## PLAN SNAPSHOT REPORT DHOWVR-2025-00018 FOR CITY OF ALBUQUERQUE

**Plan Type:** DHO Waiver **Project:** PR-2022-007397 (PR-2022-007397) **App Date:** 05/23/2025  
**Work Class:** DHO Waiver **District:** City of Albuquerque **Exp Date:** NOT AVAILABLE  
**Status:** In Review **Square Feet:** 0.00 **Completed:** NOT COMPLETED  
**Valuation:** \$0.00 **Assigned To:** **Approval**  
**Description:** We are looking to subdivide 1 existing R1D zoned lot into 2 lots. **Expire Date:**

RE: Application for Preliminary Plat for  
the subdivision of  
3017 11<sup>th</sup> Street NW

SU - 101

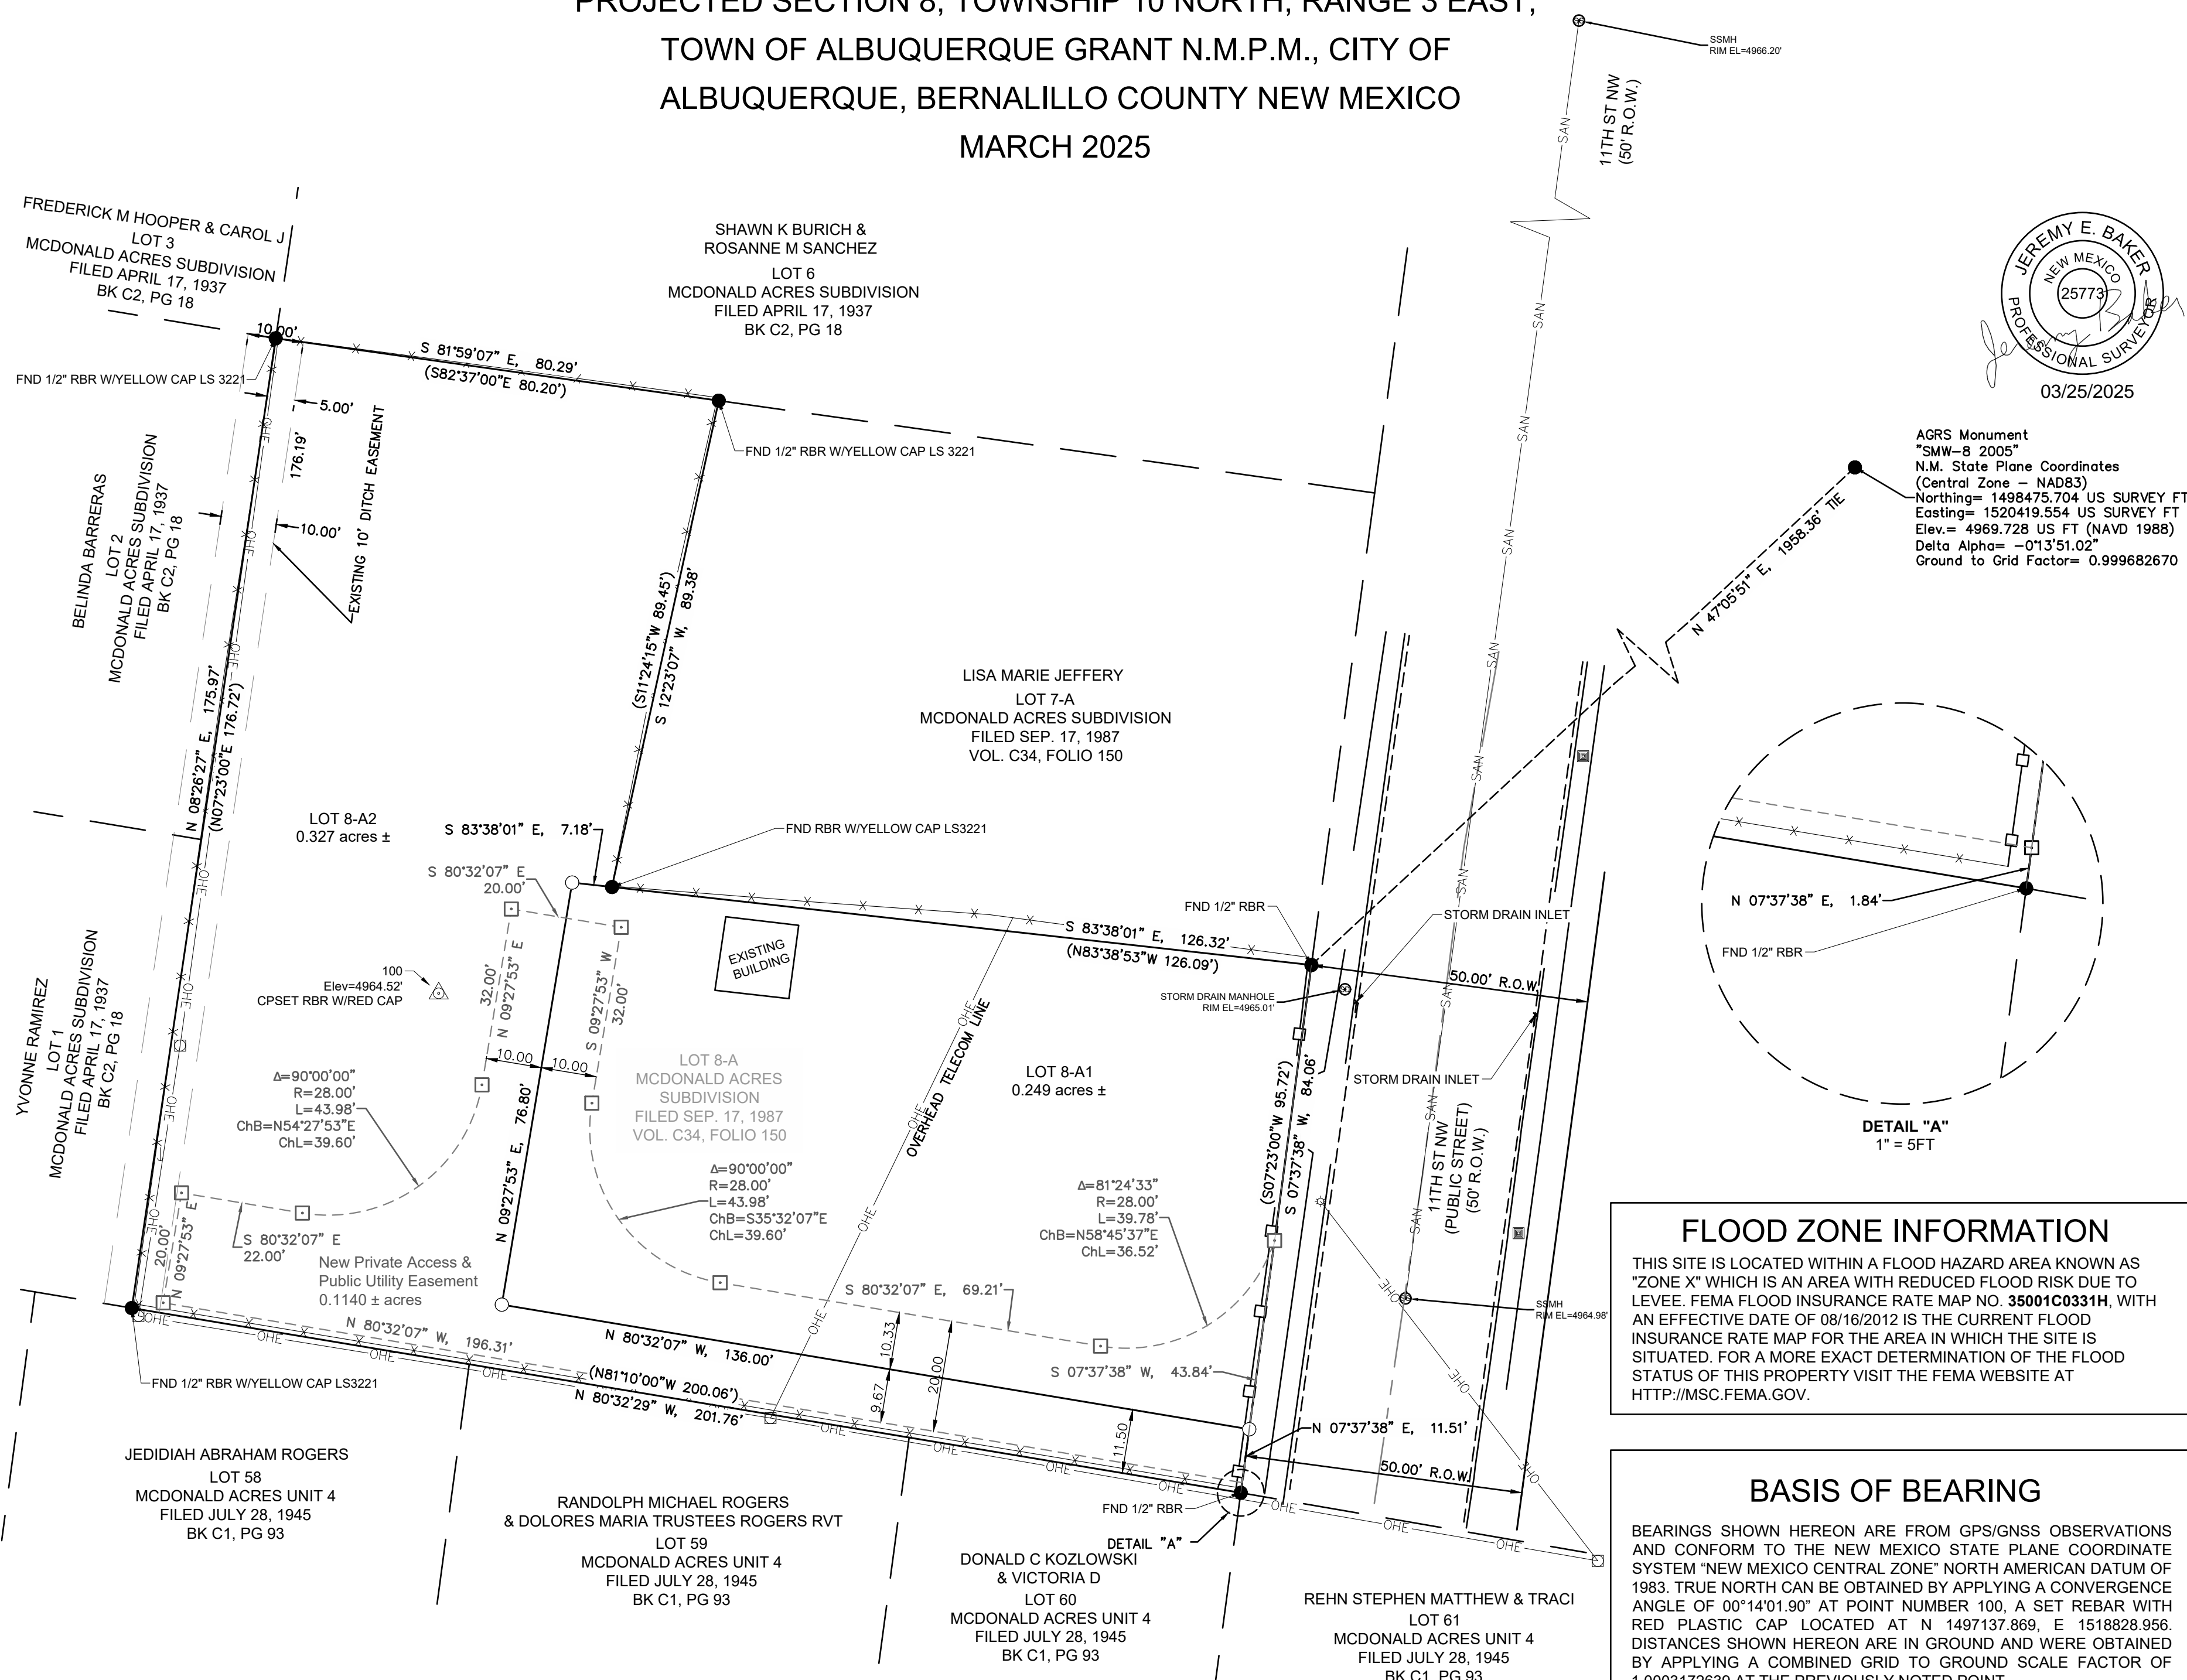
1. 11<sup>th</sup> is a local street and requires 5' sidewalk with a 4' to 6' landscape buffer. Please provide a cross section at the street dimensioning ROW, Walls or fences, sidewalk width, buffers, curb and gutter.
2. The existing driveway to this property appears as it will need to be relocated based on your proposed plat and the aerial photos.

① Drainage Plan  
1" = 10'-0"

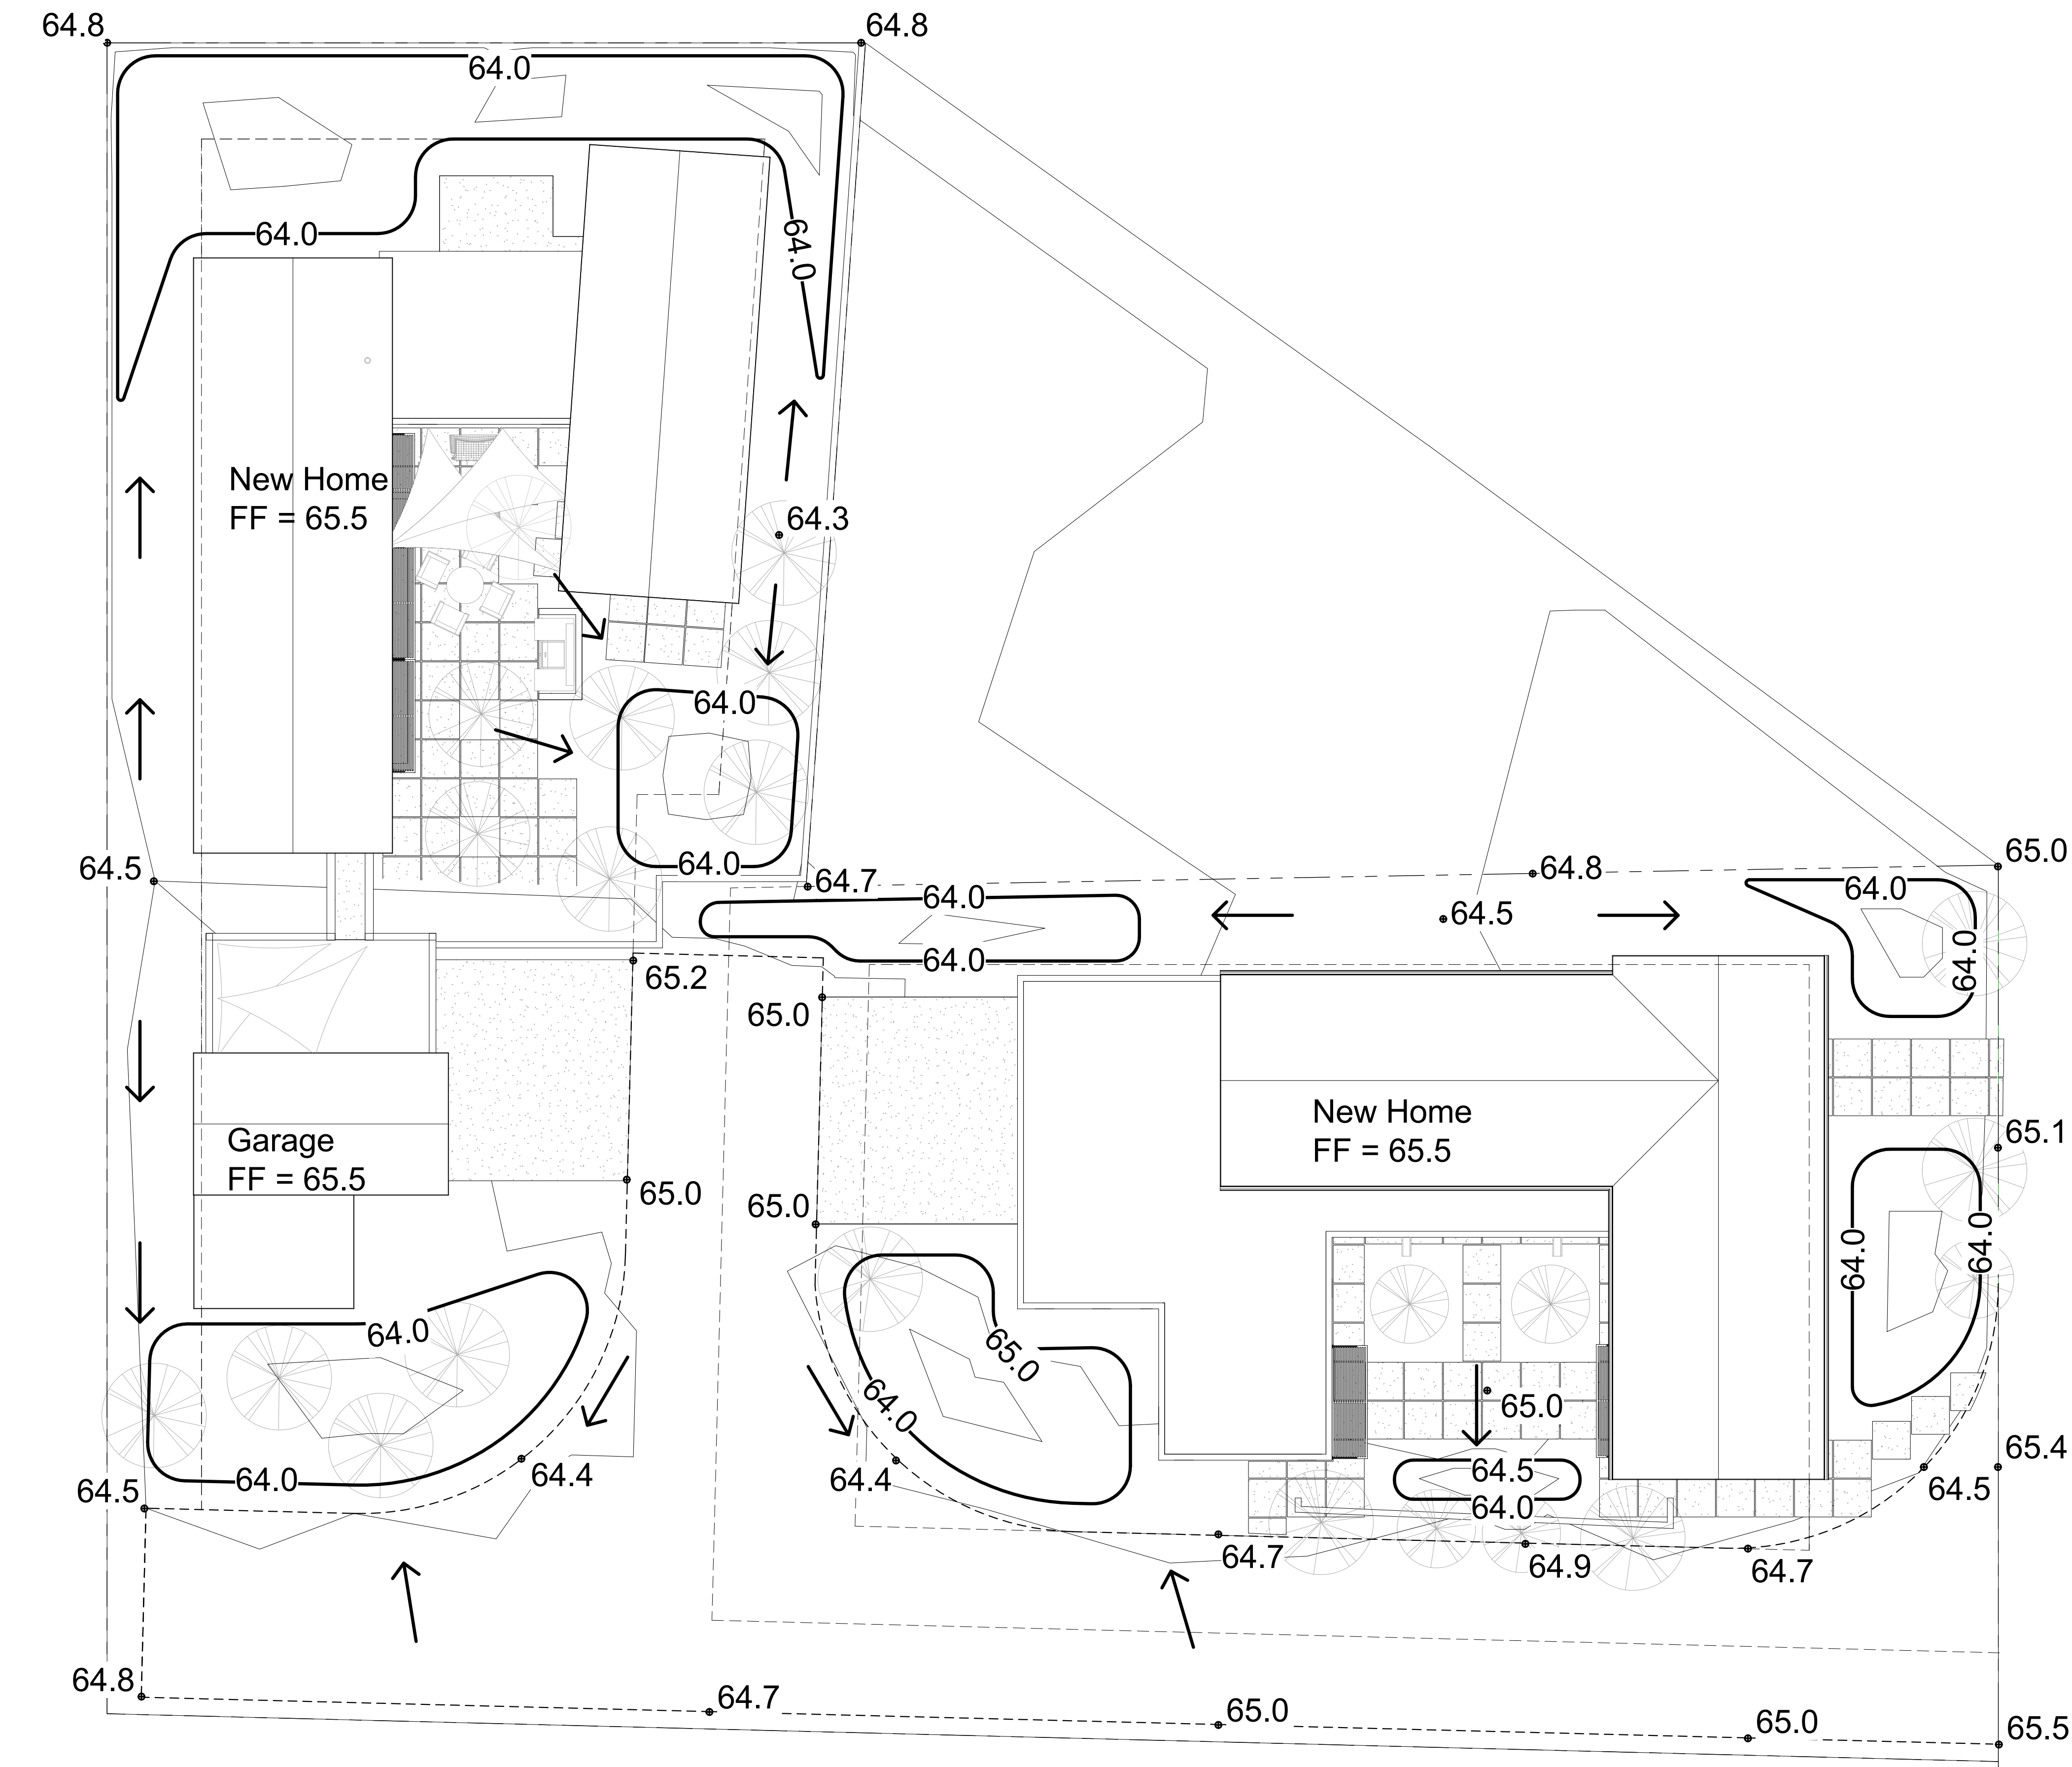
- Hydrology needs to approve a conceptual Grading & Drainage Plan prior to Plat approval.
